## Online Comment

**Application** H09-0796-25  
**Location** Land East of Forest Way Holbeach Spalding  
**Proposal** Proposed Erection of 2 Bungalows

**Name** Cllr S E Hutchinson  
**Address** c/o South Holland District Council Council Offices Priory Road PE11 2XE

PROPOSED SITE PLAN
scale 1:200

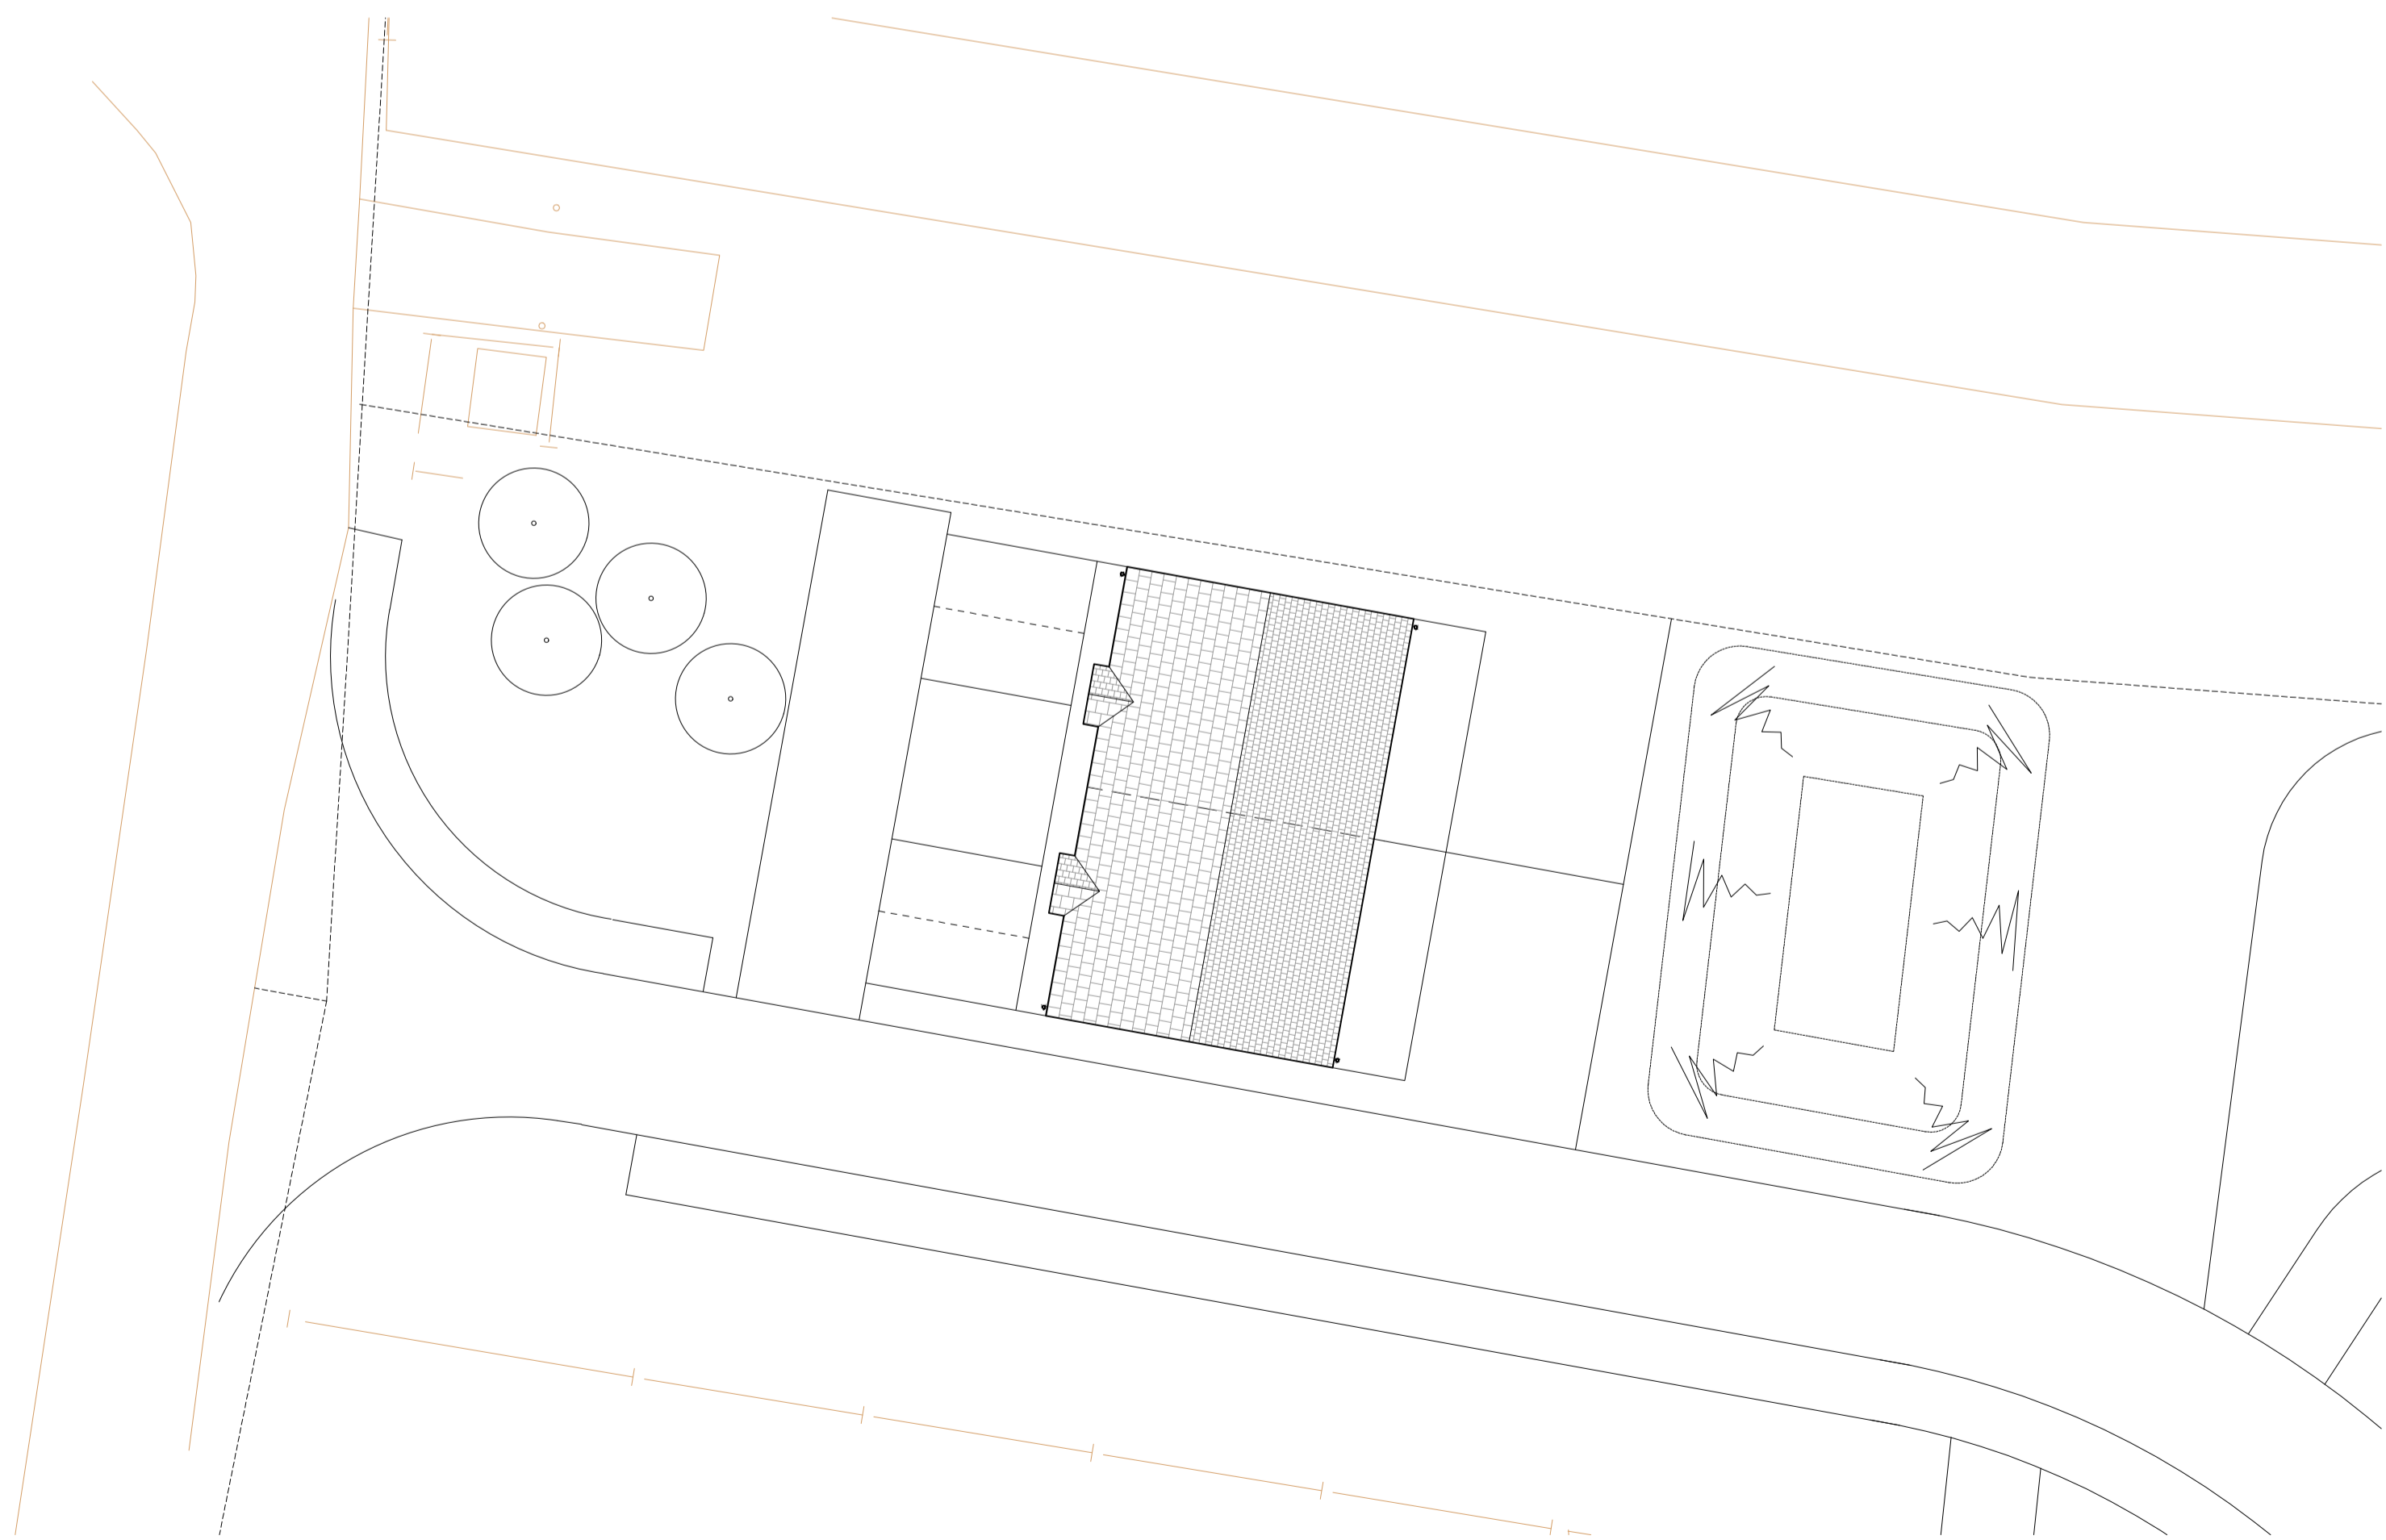
Additionally, the proximity of the proposed dwellings to the existing drainage basin raises concerns about surface water management. The basin was designed to serve the wider development and its open setting supports both function and maintenance. Introducing built form so close risks compromising its capacity and accessibility, potentially increasing flood risk to nearby properties.

These features were essential to the acceptability of the development outside the settlement boundary. The current proposal would erode this soft edge, placing built form into an area intentionally left open. The proposed bungalows would fragment the open space, creating a hard edge adjacent to the drainage basin, which would be enclosed between new and existing dwellings- undermining its open character and raising concerns about long-term maintenance and drainage performance.

This open space currently provides a positive visual break, contributing to the semi-rural character of the entrance and acting as a transition zone to the development. The proposal would disrupt this transition, creating a backland-style layout that fails to integrate the existing development with the street scene.

The proposed access, stepped back off Forest Way, would result in a staggered and incoherent building line along Wignals Gate. The entrance would lose its open character, and the development would appear disjointed and poorly integrated, with narrow access and limited landscaping. This would significantly reduce the positive views into the site, which currently help the existing development feel open and connected.
